Date: 30 November 2018

RE: Kendall Bay Sediment Remediation Project (SSD 6701) – EPA Submission on Environmental Impact Statement.

Kendall Bay Sediment Remediation Project (SSD 6701)

Figure 2: Northern Remediation Area (S&W, 2018)

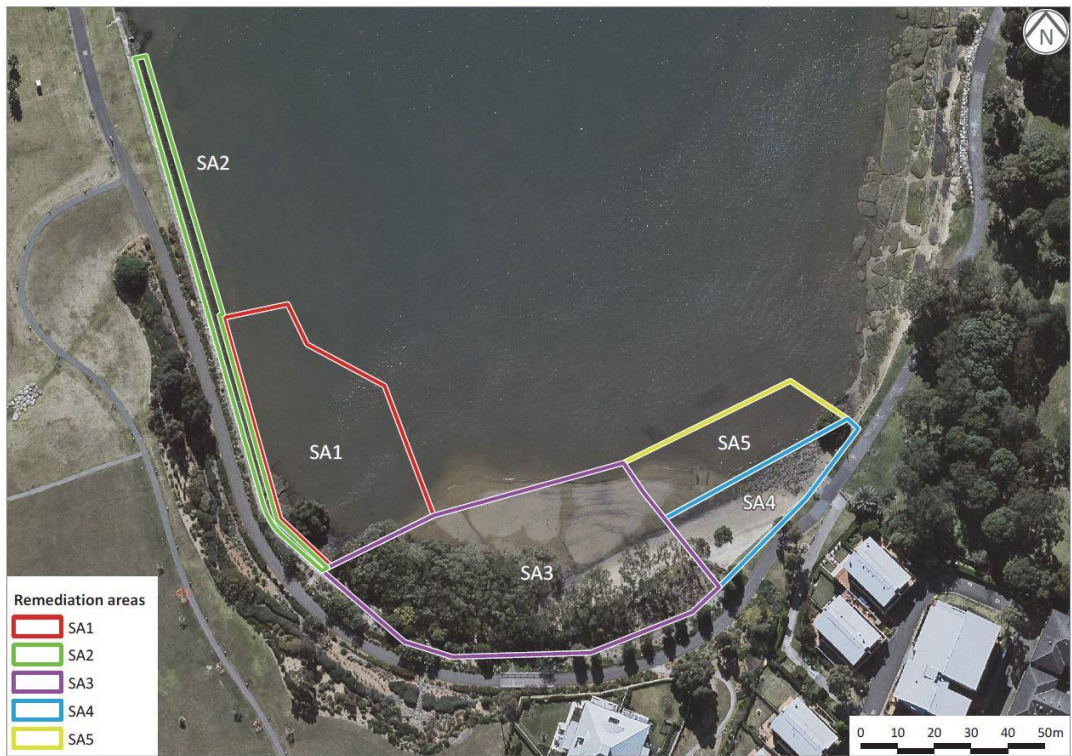
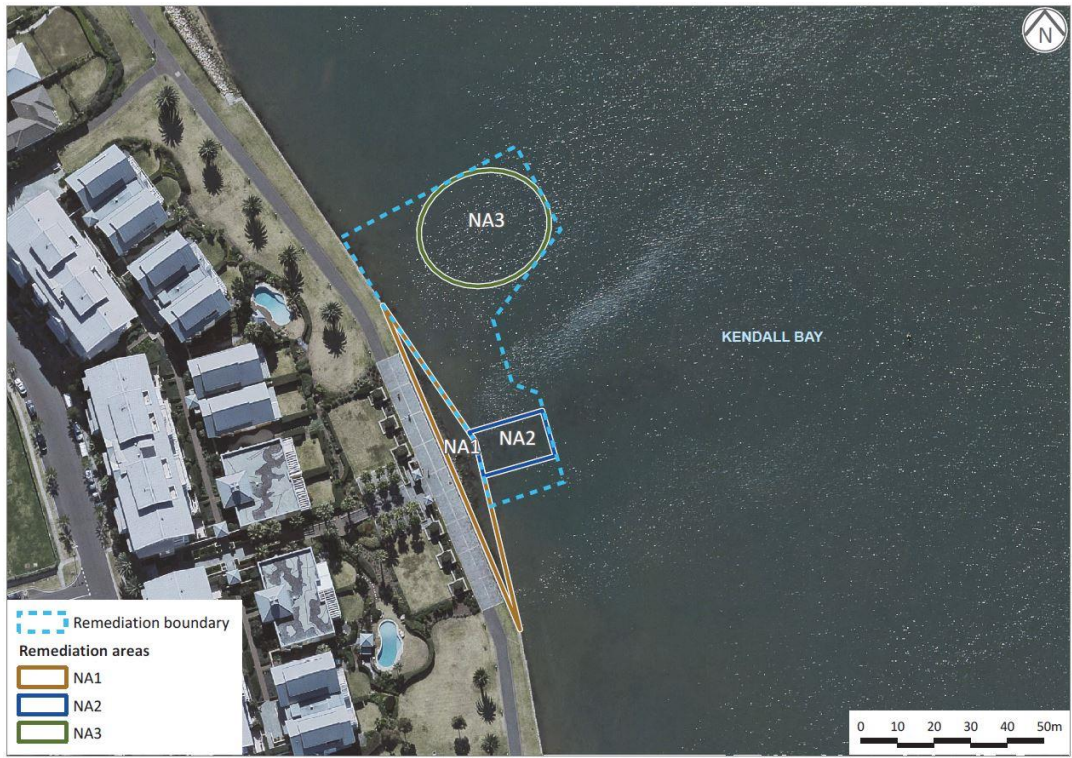
EPA subsequent comment email 21 November 2018: Please confirm the scope of works proposed for remediation between the areas NA1, NA2 and NA3.

Jemena response as discussed in meeting 27 November 2018: The ‘intervening area’ has the same scope of works proposed as the areas shown as NA2/NA3 (i.e. in situ stabilisation and capping layer). Reference to NA2 and NA3 in the RAP and EIS includes the ‘intervening area’.
